13 December 2012

**Major Project 11_0046 – Modification of Concept Plan MP05_0086 and the Construction of Stage 3 Residential Development – Buildings 11-17
61 Mobbs Lane - Epping – former Channel 7 Site (Epping Park)**

Dr. Robert Lang
Chief Executive Officer
Parramatta City Council

DRAWING TITLE: LOWER GROUND 2	PROJECT NO:	DATE:	DRAWING No:	REV:
	697	MAY 2012		
	DRAWN BY:	SCALE:		
	GO	As indicated	A0001	1
	CAD FILE:

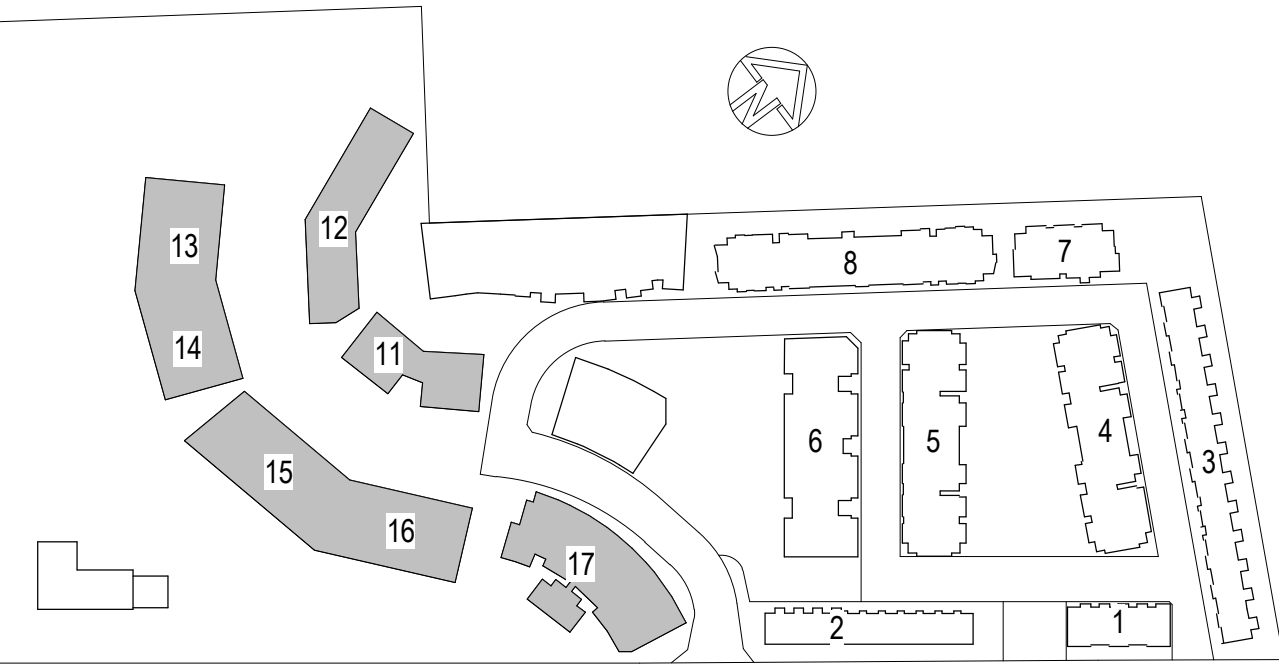
- There are a significant number of stacked parking spaces within the basement levels and this is not a preferable, or necessary design layout for a new development.

- In accordance with Tables 3.1 and 3.2 of AS 2890.1-2004, the driveway access to the basement level should be separate entry (6m wide) and exit (4m to 6m) with a physical separator (1m to 3m wide).

PODIUM PLAN

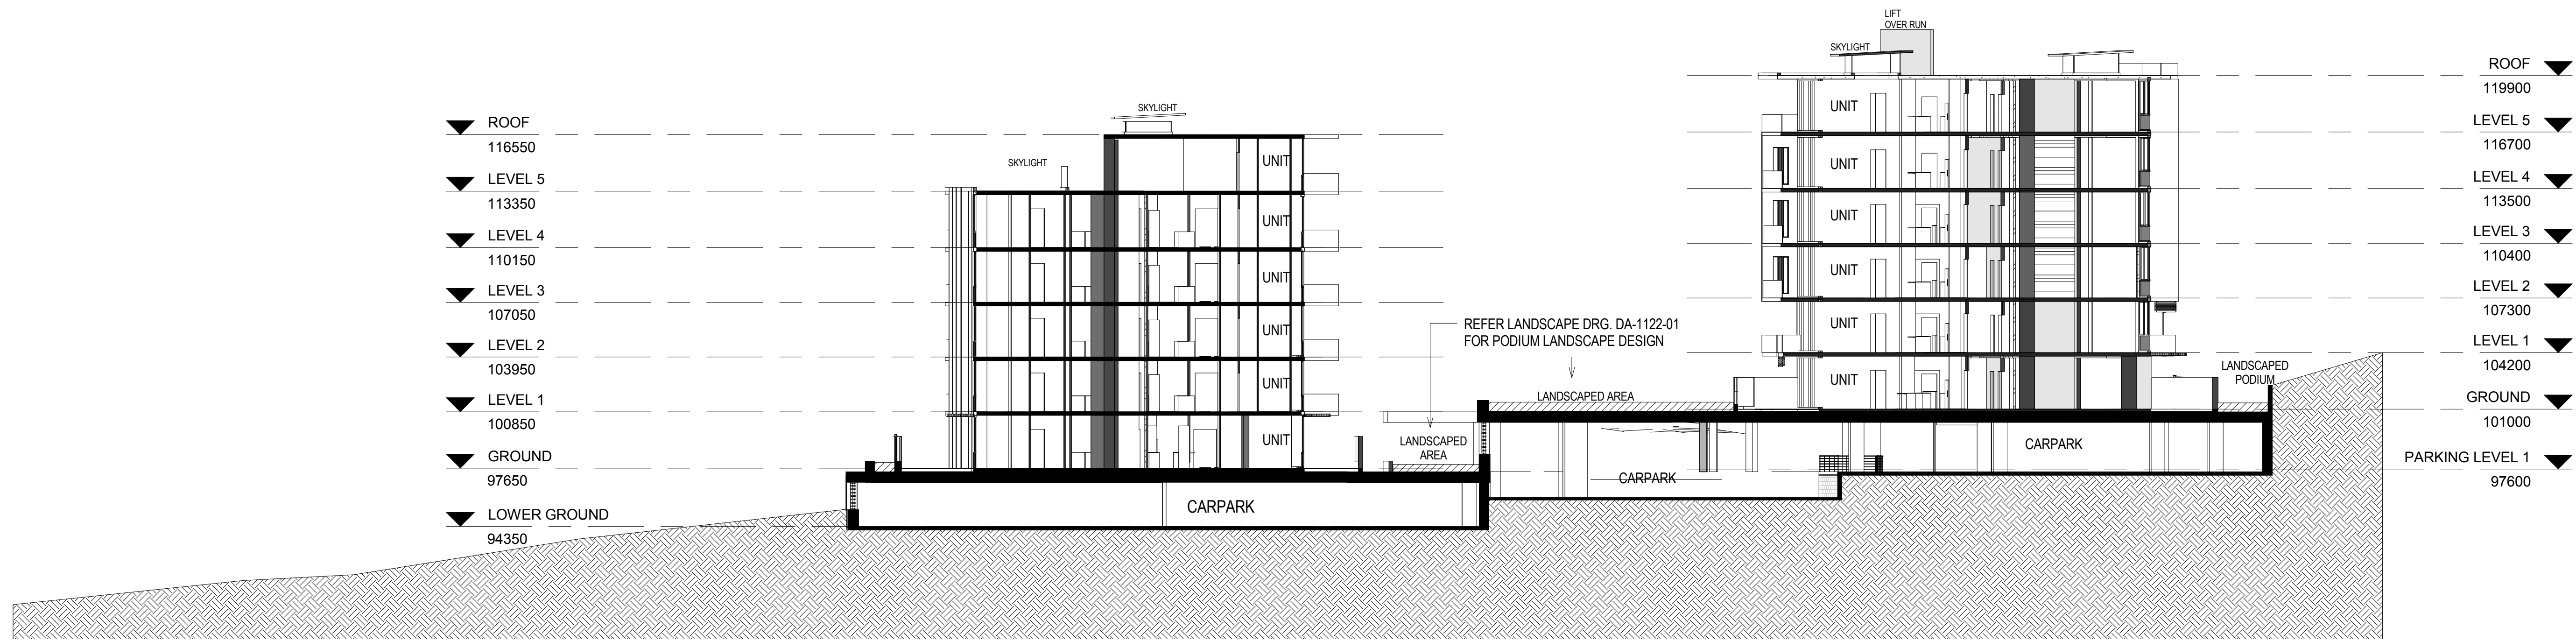
Concern is raised with the proposed deletion of the internal road on the western section of the site and the provision of a combined basement car park to service the dwellings within Buildings 11 to 16.

Although the deletion of the internal road and provision of the landscaped podium allows for a larger open space area, concerns are raised with respect to the proposed basement design. These issues relate primarily to crime prevention and landscaping opportunities.

The approved Concept Plan has a street providing formal street addresses to Buildings 11, 12, 13, 14, 15 and 16. This street has now been replaced with a landscaped podium and a single ramp accessing the basement carpark. As a result of the deletion of the street, the area will not be appropriately activated and will lack passive surveillance. The open space between the buildings has the potential to be unsafe, for example if a resident or visitor of Building 12 takes a taxi at night, the drop off point is not only a considerable distance from Building 12 but there will be inadequate passive surveillance along the path.

The approved Tree Master Plan indicated the street environs as a "Parkland Spine" with the provision of large, endemic canopy trees between the rows of buildings which could attain a height of between 20m-40m at maturity. The proposed combined basement results in a loss of deep soil zone and landscaping opportunities within the development. The proposed application indicates the provision of small trees planted on-slab which does not provide for appropriate scale and type planting in comparison to the height of the proposed buildings.

It is therefore recommended that the approved street is reinstated to ensure security for residents, visitors and the general public through passive surveillance and activation and provide for the envisaged parkland spine through the site.

SITE SECTIONS - 1

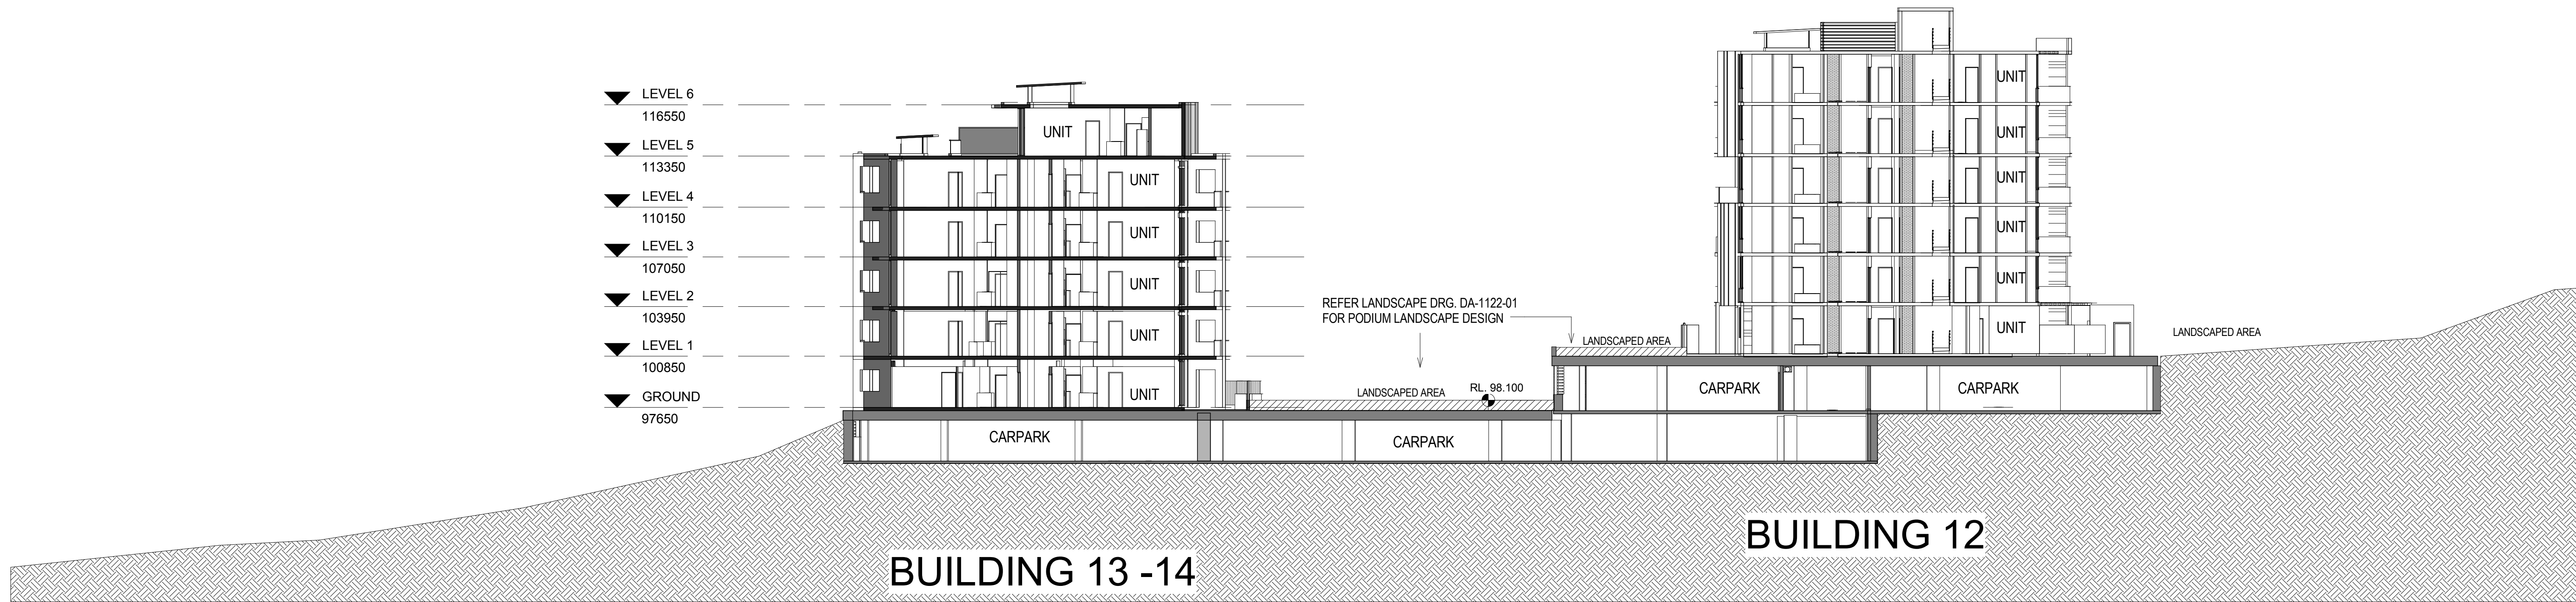
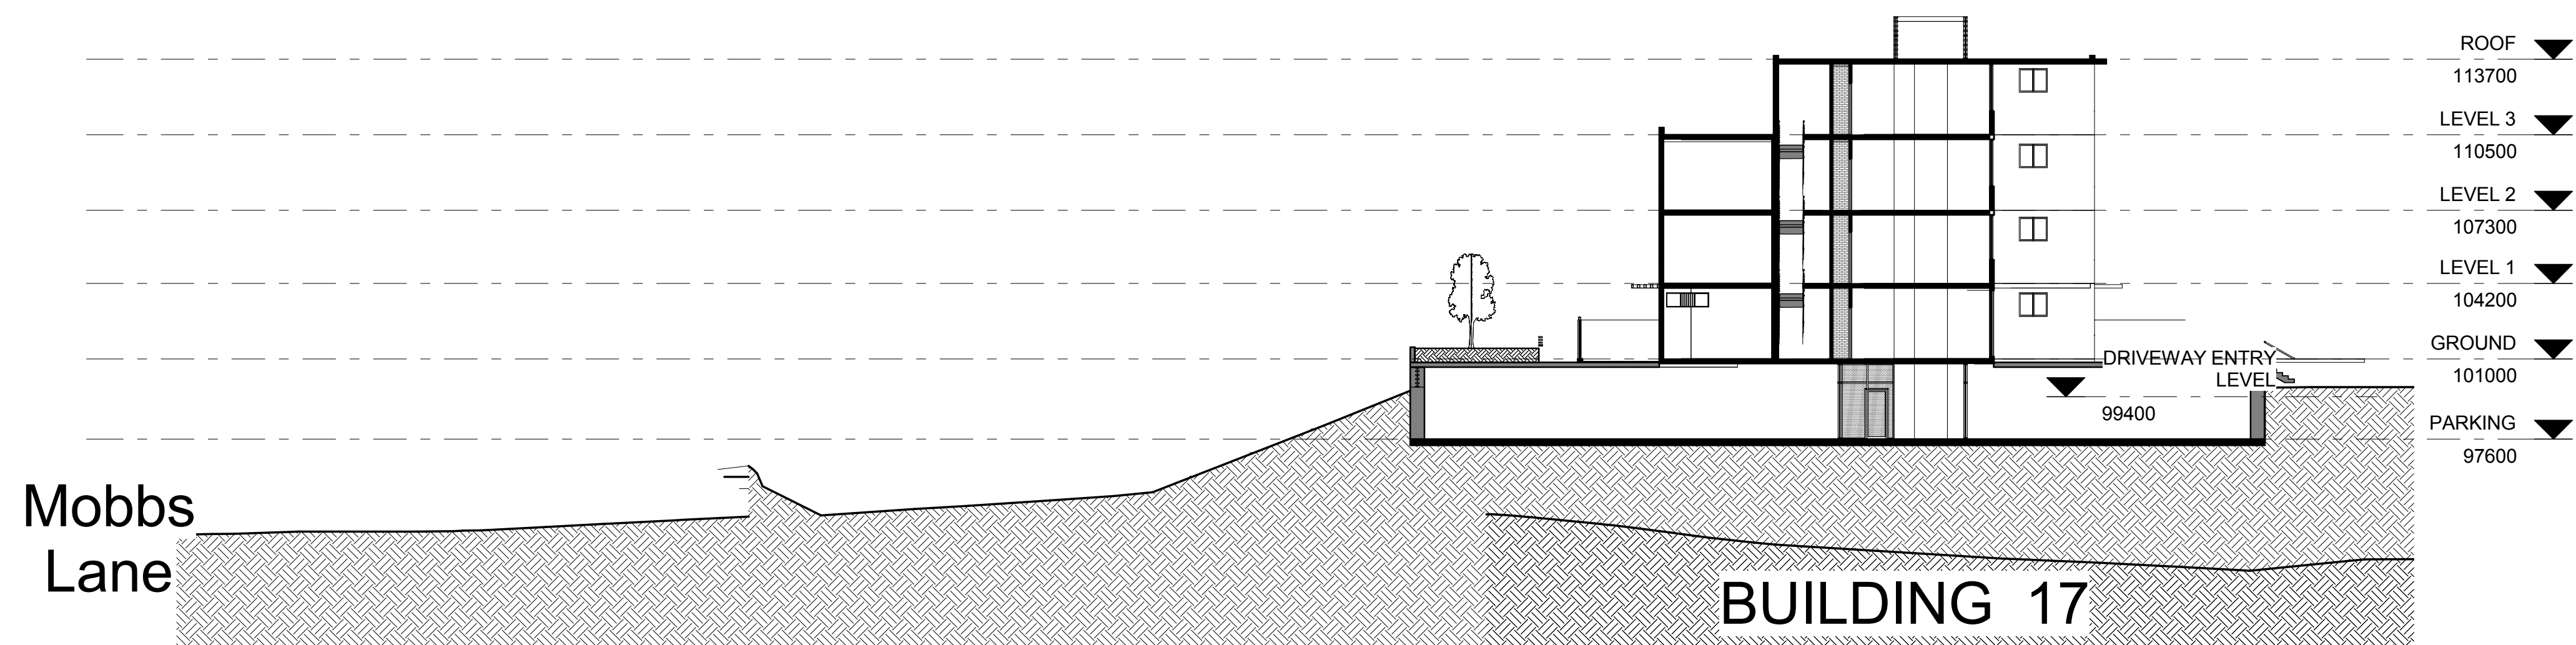
It is difficult to properly assess the heights of the buildings (particularly in terms of the basement projections) as no natural ground levels have been provided on the plans and the levels on the submitted survey cannot be ascertained. It is therefore considered that the Department of Planning and Infrastructure carry out the detailed assessment to verify compliance with heights.
